PETITION NO. 2020-057
DEVELOPMENT STANDARDS
Lakemont Property Investors, LLC
6/15/2020

Schematic Site Plan Rezoning Petition #2020-057

Charlotte, NC
June 15, 2020

Schematic Site Plan Rezoning Petition #2020-xxx

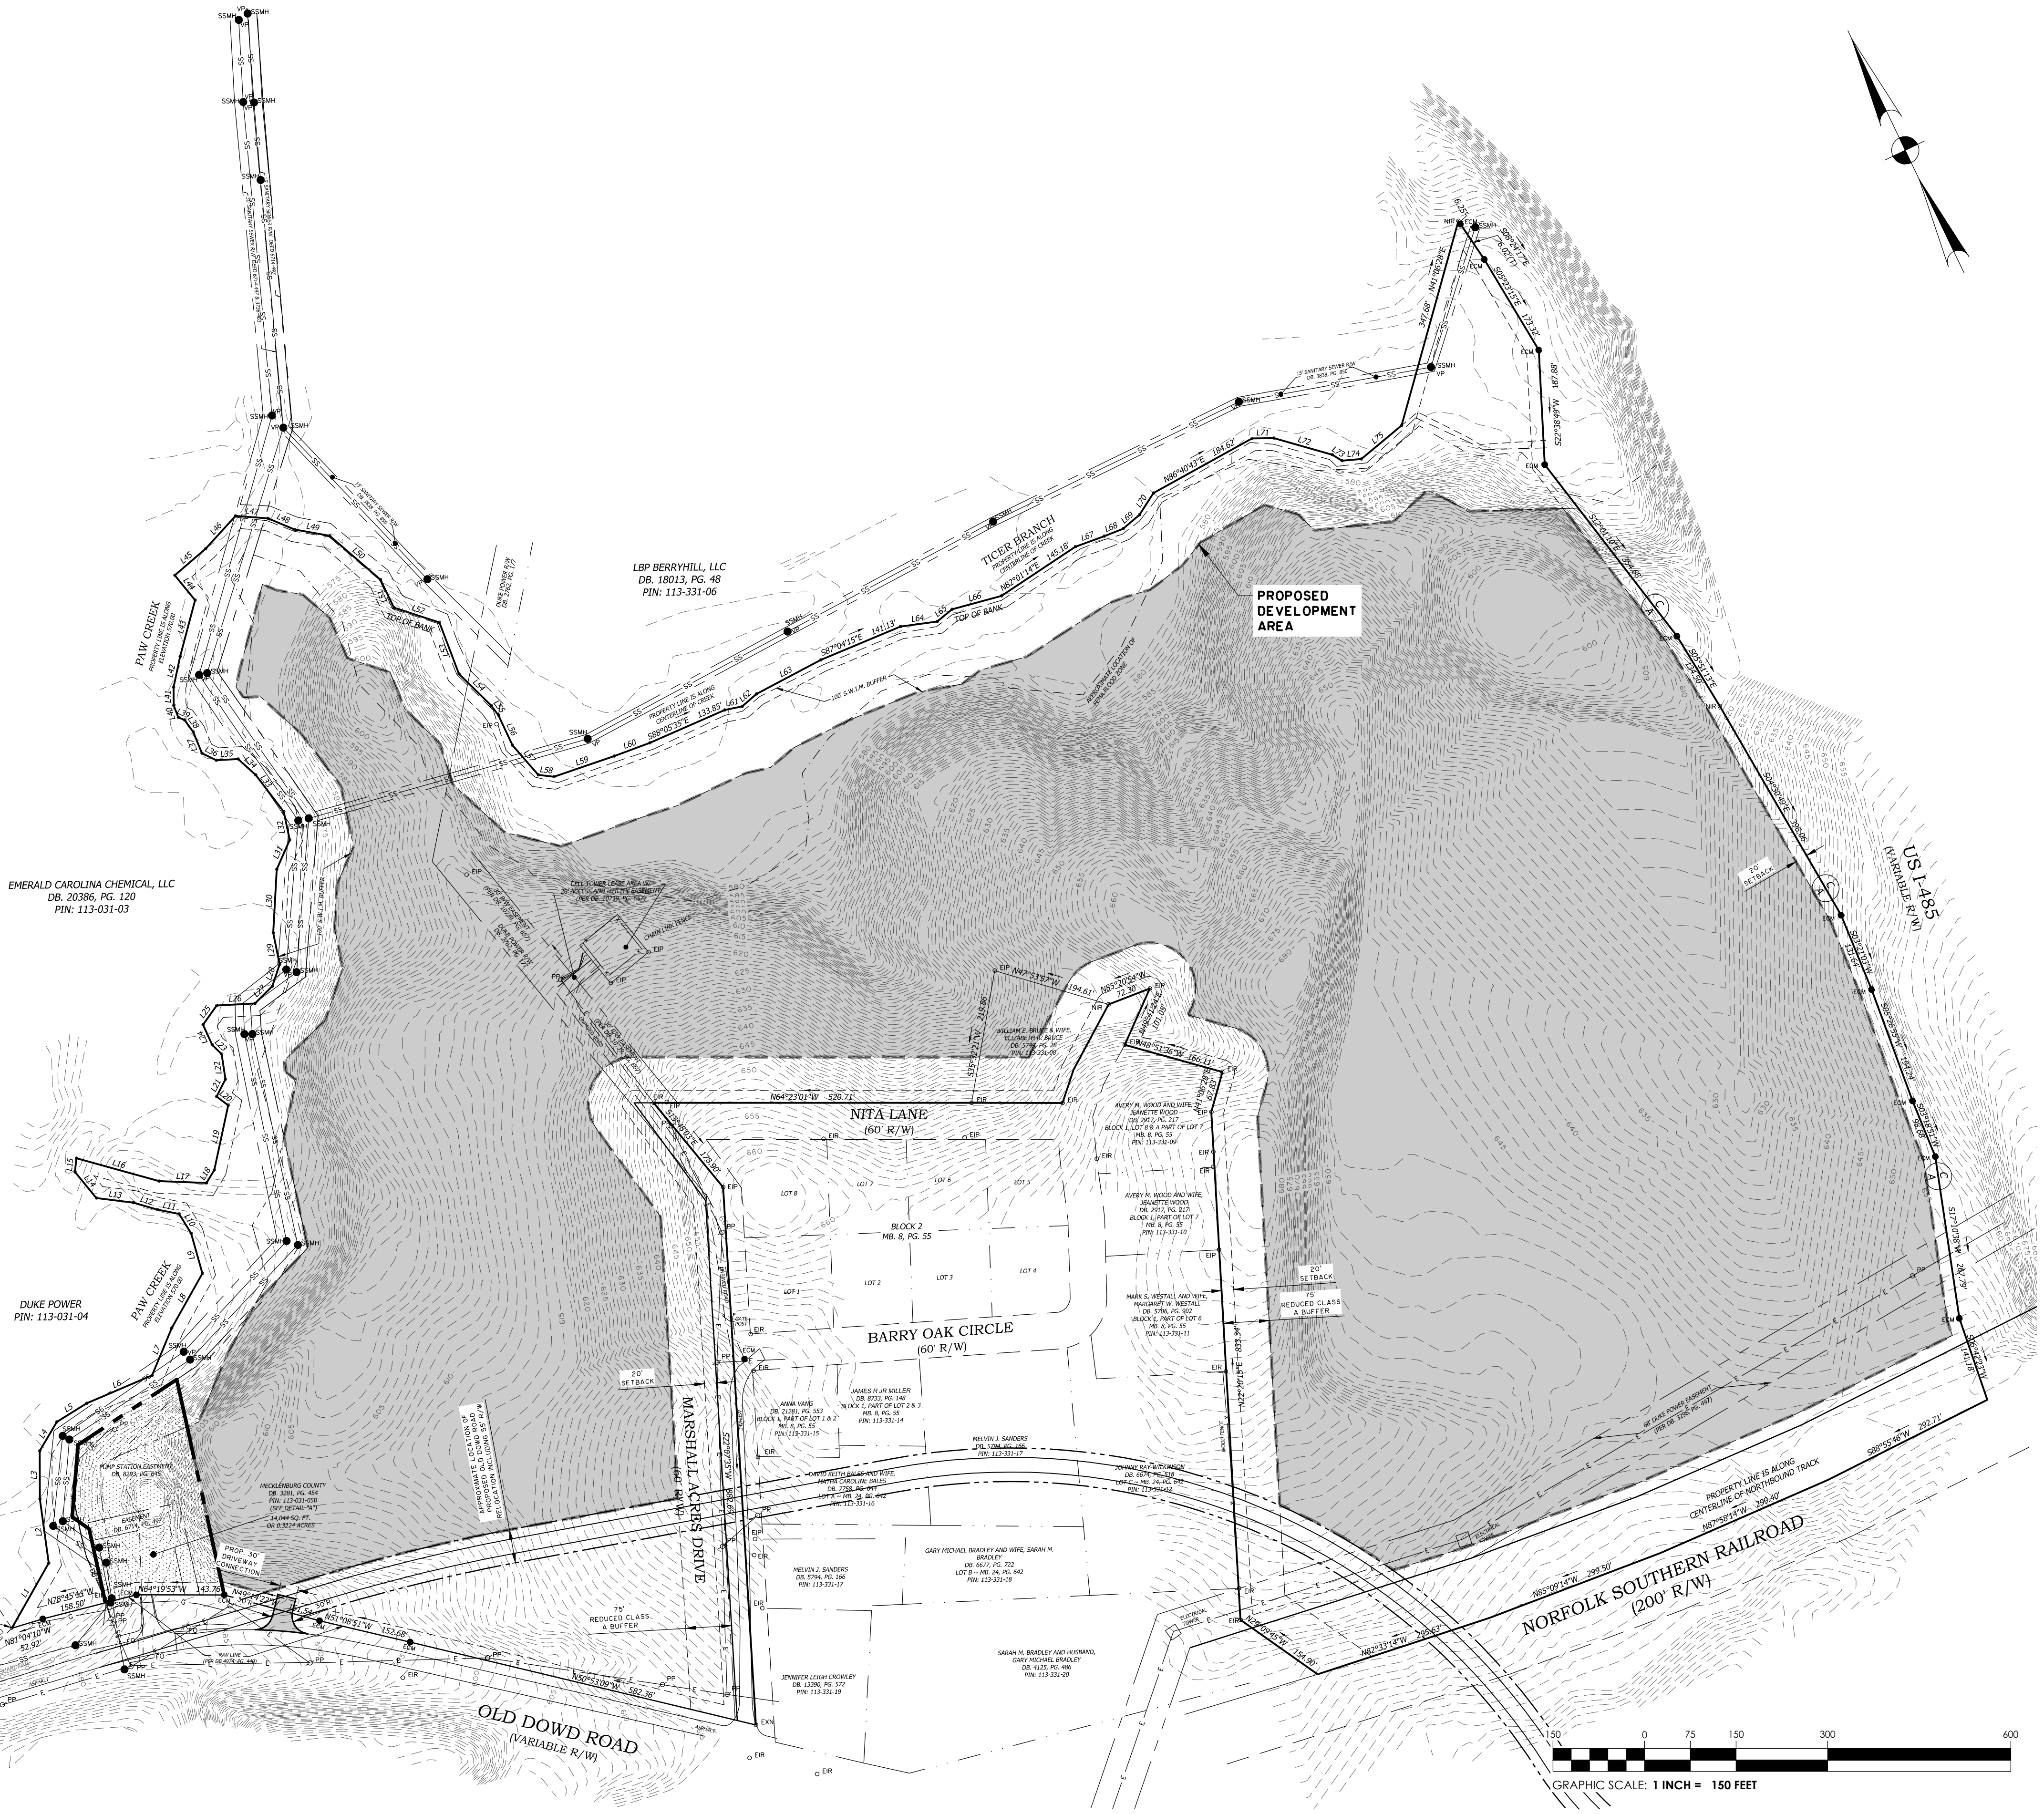
The parking/ building area is still pretty large and generalized. Please consider locating the building footprints.

Increase the size of buffer in this location.

100' Class A is the minimum with reductions in areas shown on the plan

Please clearly label the rezoning boundary line along the property line with the buffers included in the petition.
